**Case Officer:** Gemma Magnuson      **Recommendation:** Refuse

**Applicant:** Mr & Mrs A Pasteur

**Proposal:** Creation of jib door and stair, and associated works to include the removal of ceiling joists

EXISTING FIRST FLOOR PLAN 1:200

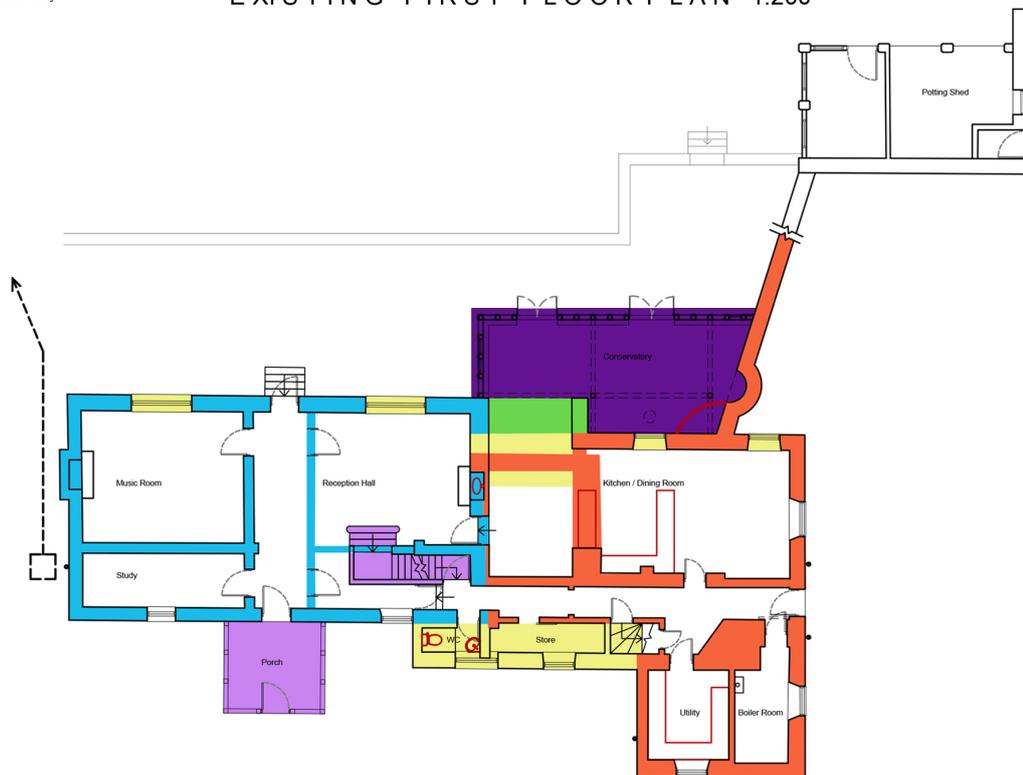
- In previous applications it was thought that the only historic fabric to be lost was the walling in the gable end, however the return visit to the site revealed that it would also involve the loss of part of the lath and plaster ceiling (which had already been taken down without consent) and ceiling joists in the service wing in order to allow for headroom above the stairs between the two phases of the building.

- 8.9. The current application also details the loss of a section of ceiling joists, and lathe and plaster ceiling, an element of the proposal that was not included in previous submissions. The development would therefore involve the loss of more historic fabric than had previously been appreciated.

- 8.10. As the Conservation Officer has advised, regardless of the specific phasing and development of the building, fundamental issues with the proposed breach between these physically and functionally distinct areas of the building remain. The development is considered to lead to harm in terms of the understanding of the evolution of the plan form of the building, with both elements displaying differing characters internally such as the level change, lower ceiling heights and room sizes.
